**Consultation Response from KC,
Ecology Unit**

2026/92432 adj to, 46, The Fairway, Fixby, Huddersfield, HD2 2HU

Formation of a vehicular access and relocation of existing gates

Responding Ref: 2609/42

Proposed Vehicular Access and
Highway Alterations

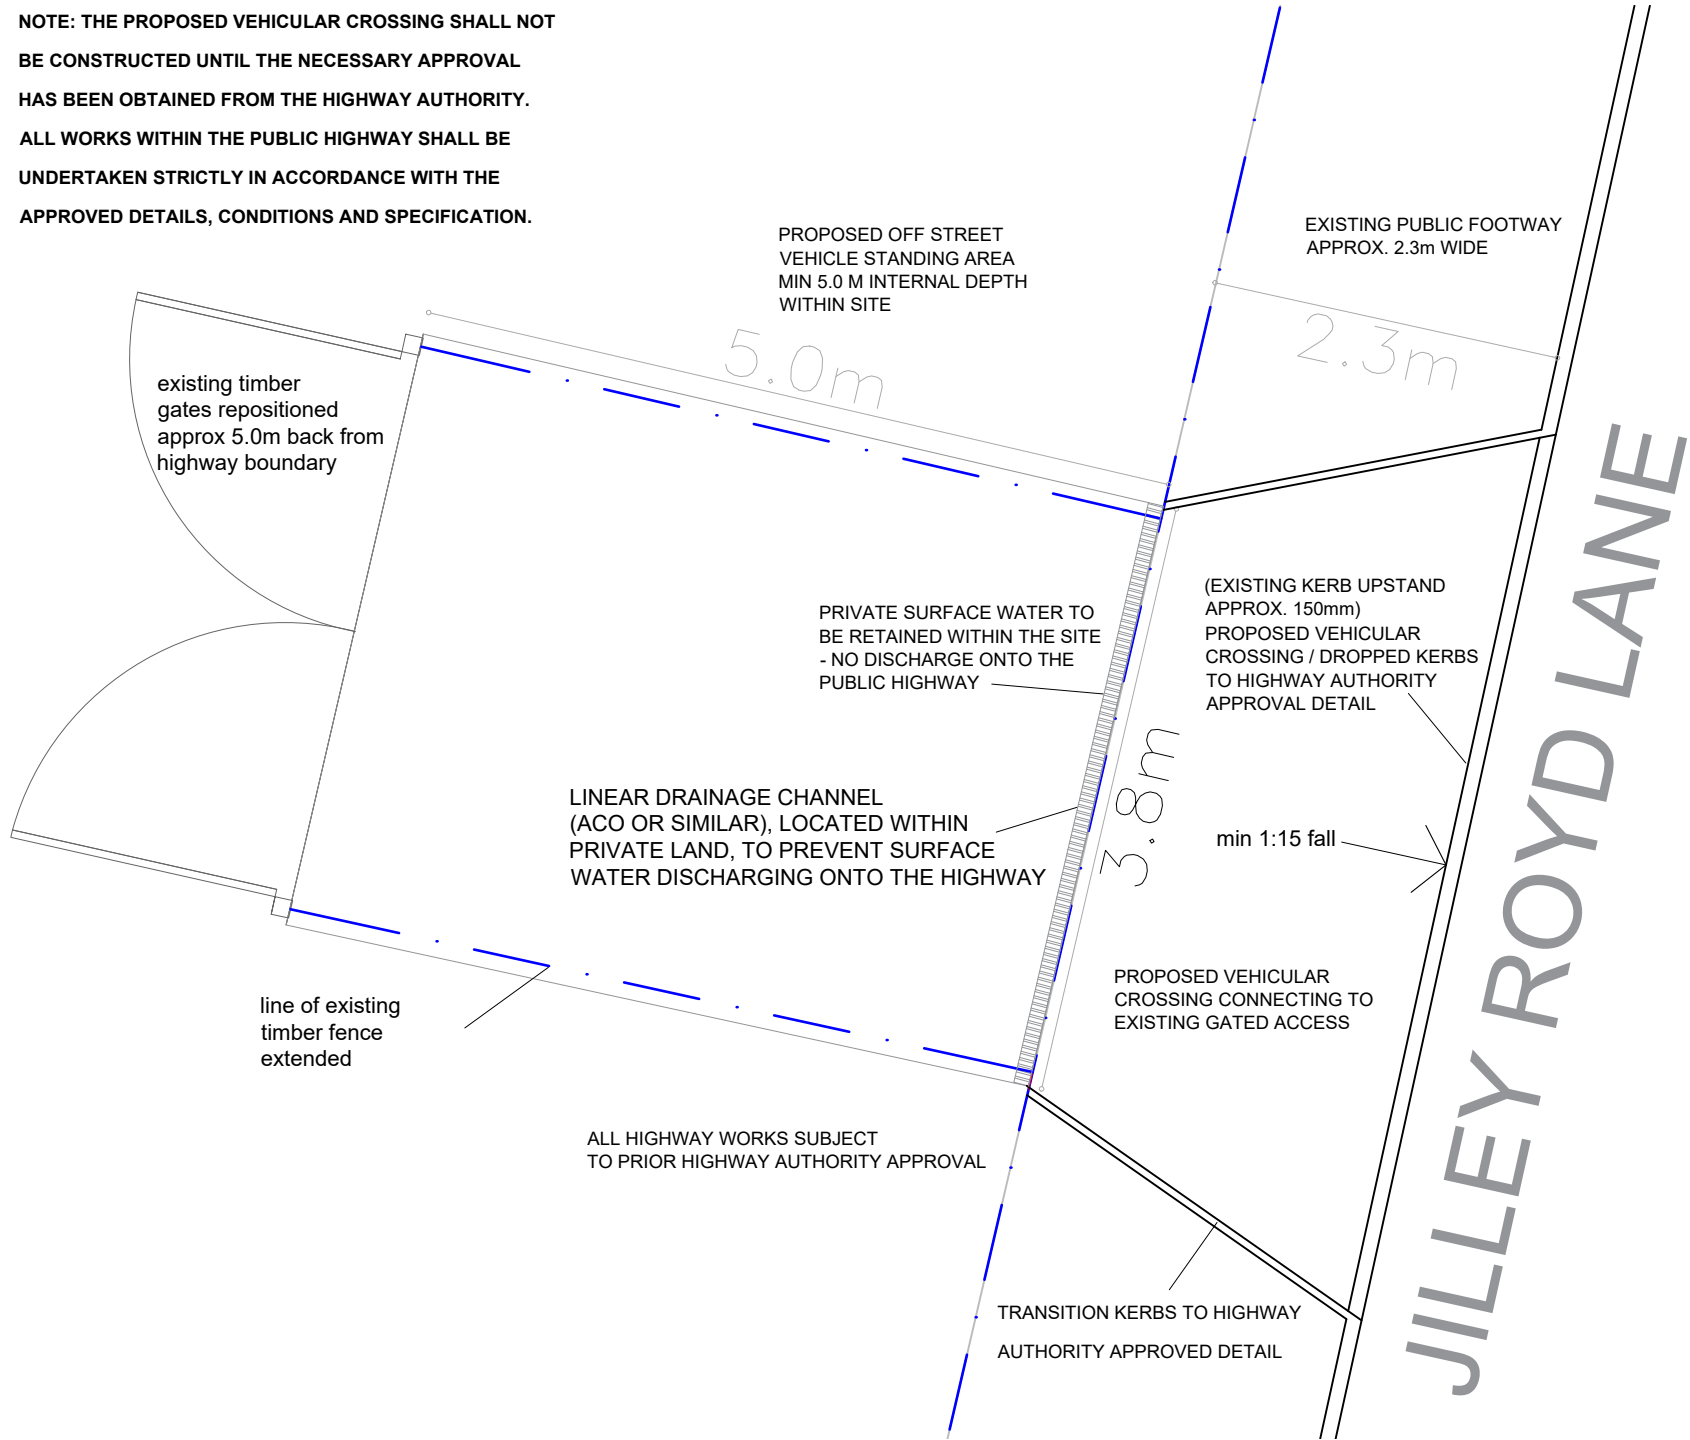
The Planning Statement (Unknown, n.d.) and Arboricultural Supporting Statement (Unknown, n.d.) states that no trees or vegetation will be removed as part of the proposals, however the plans to relocate the gate further into the woodland may result in works within the root protection area of these trees. I would also question the need for vehicle access to the woodland and also the effective use of this entrance. Is it expected that the cars will park in front of the gates proposed and reverse out into the road, or will the cars be expected to turn around in the woodland? There is potential that this would damage the soil and the tree roots. What woodland management is proposed that requires this access?
